WEST SUSSEX COUNTY COUNCIL CONSULTATION

TO:	Arun District Council FAO: Maria Tomalova
FROM:	Highways, WSCC
DATE:	07/04/2020
LOCATION:	Rear of Blackberry House, Berry Lane, North Bersted, PO22 0AF
SUBJECT:	BE/13/20/PL Single storey dwelling with detached carport (alternative to BE/64/17/PL). This application may affect the North Bersted Conservation Area.
DATE OF SITE VISIT:	N/A
RECOMMENDATION:	Advice
S106 CONTRIBUTION TOTAL:	£N/A

TITLE
FLOOR PLAN

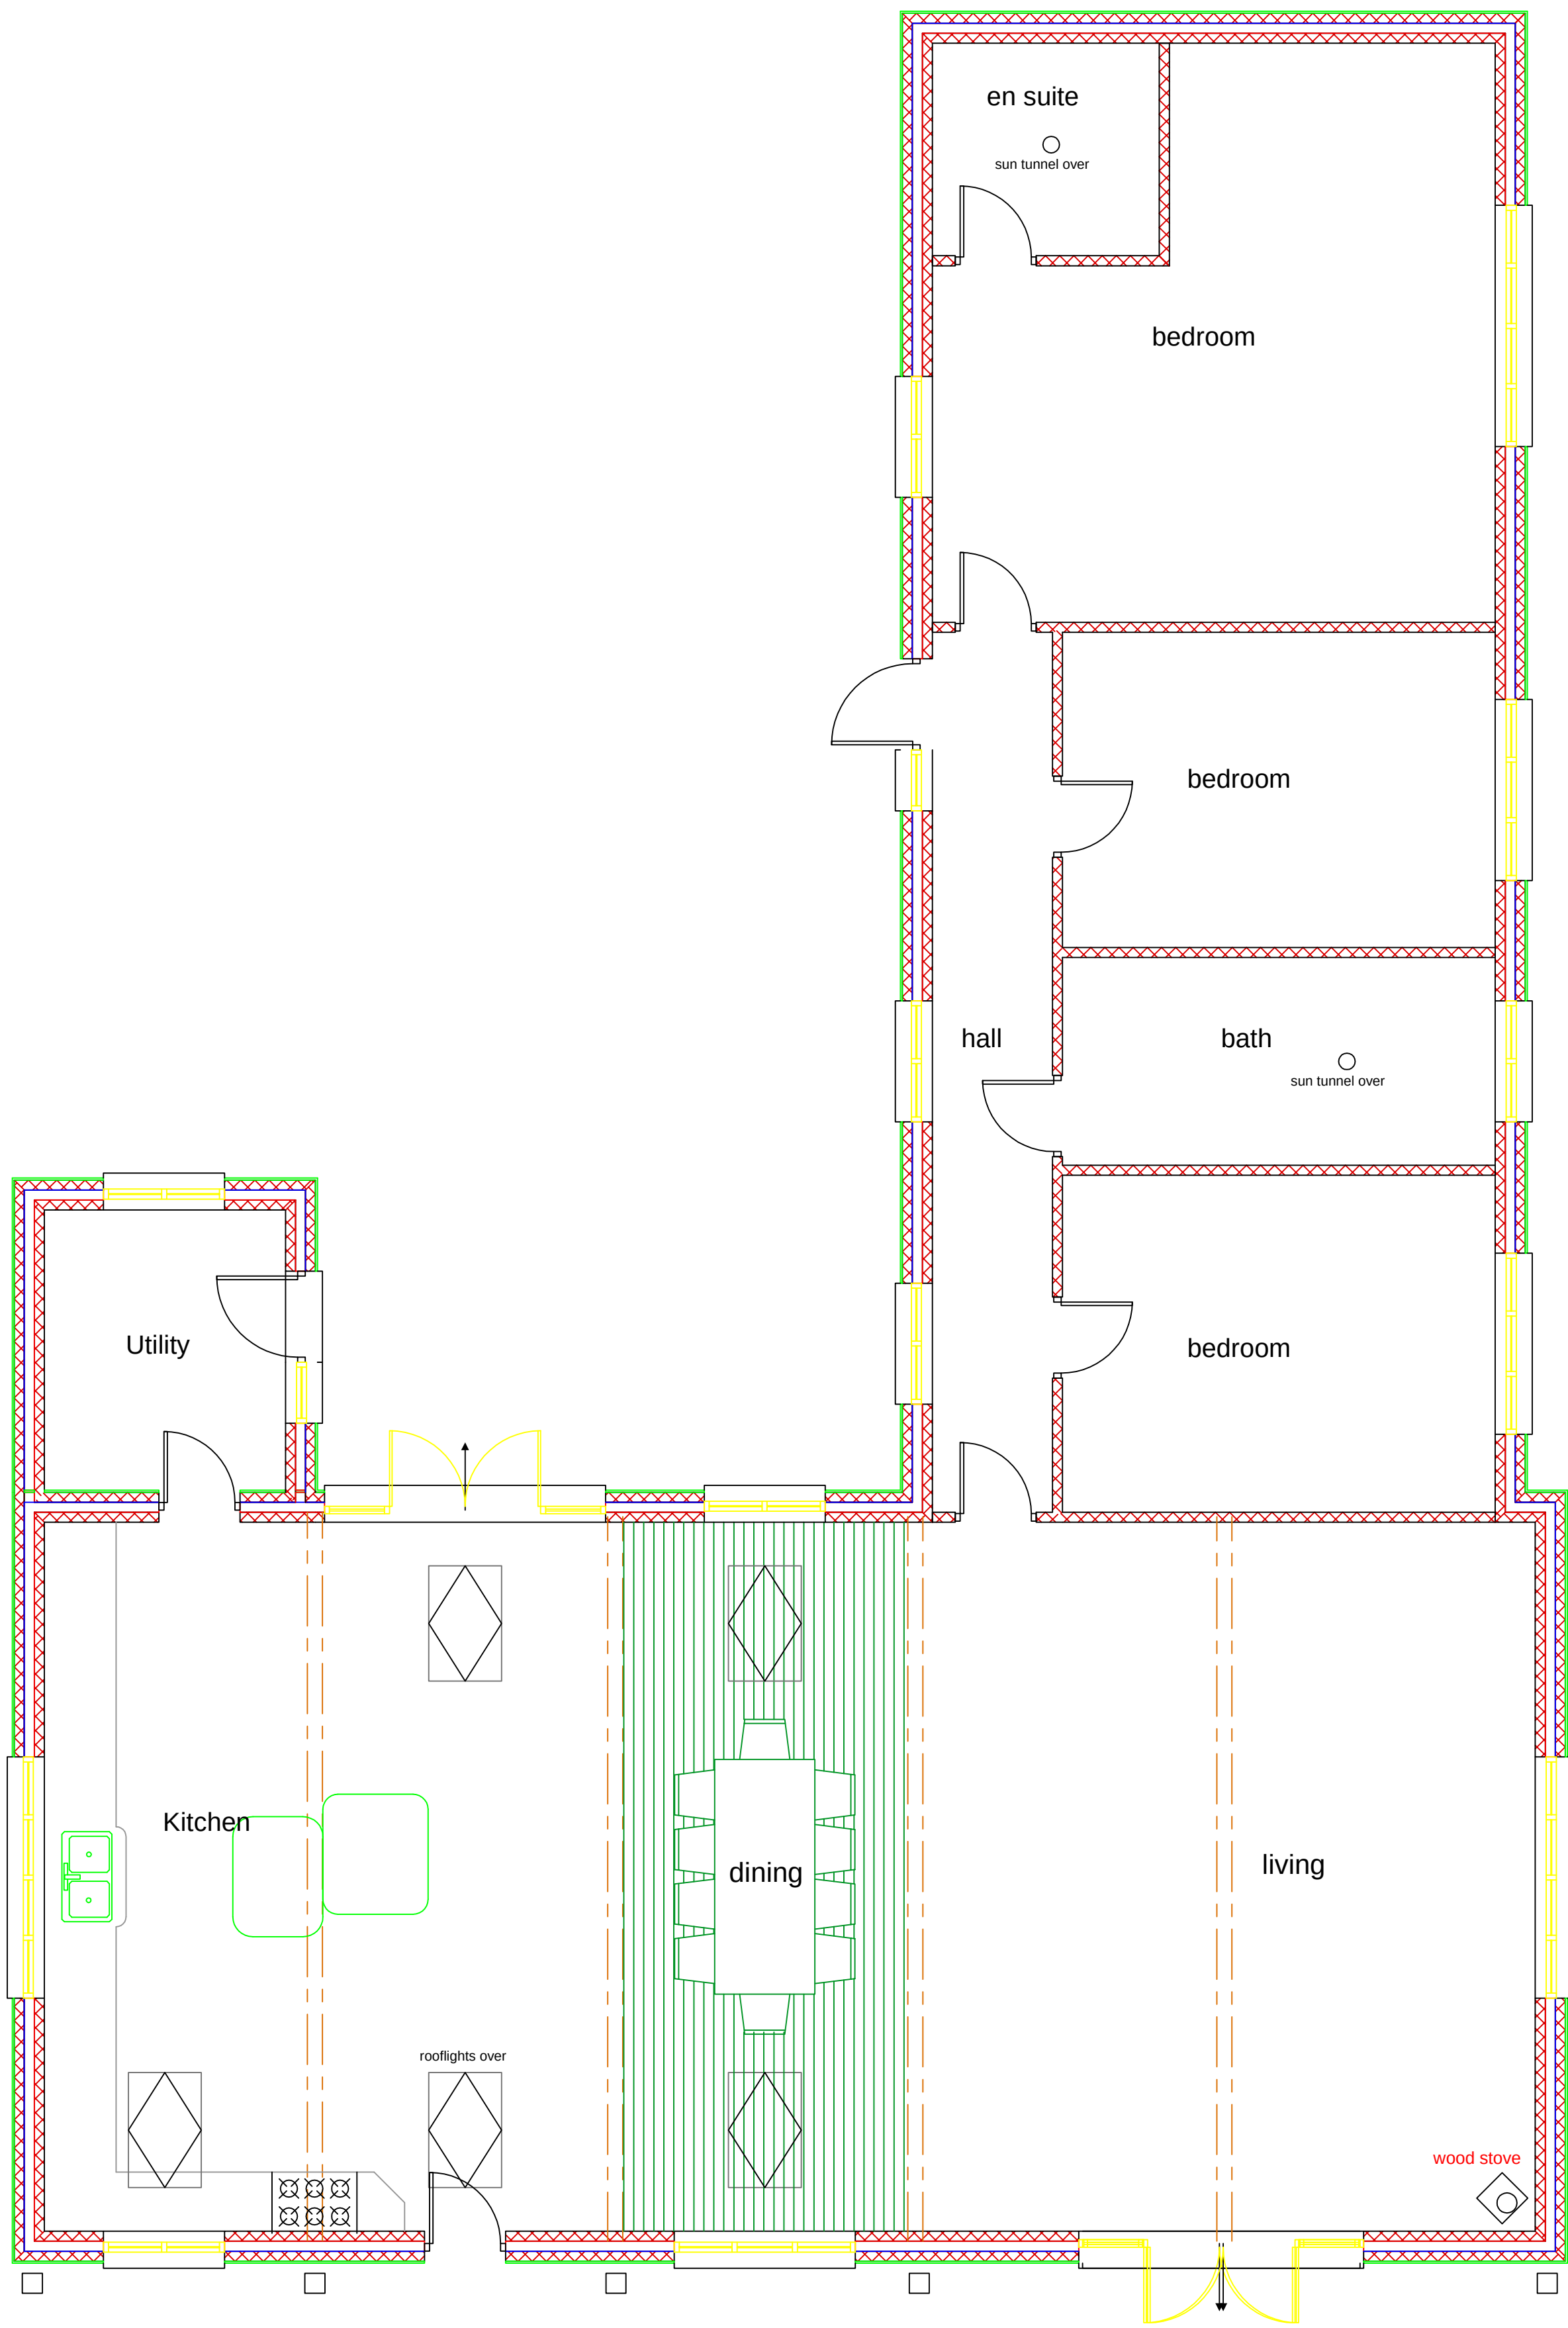
The applicant proposes a double car port for vehicular parking. Under Arun Parking Standards (adopted January 2020), the LHA would anticipate that two parking spaces would be sufficient for a dwelling of this size and location. As such, the LHA considers the proposed parking provision to be sufficient.

There appears to be sufficient room within the driveway for on-site turning to be achievable, allowing vehicles to exit the site in a forward gear.

In regards to cycle parking, Arun and WSCC parking standards require dwellings with three bedrooms to provide and secure and covered cycle parking for at least two cycles. The applicant has not demonstrated cycle parking in the plans. The LHA advises the applicant to include cycle parking in the plans, to promote the use of sustainable alternative modes of transport to the private car.
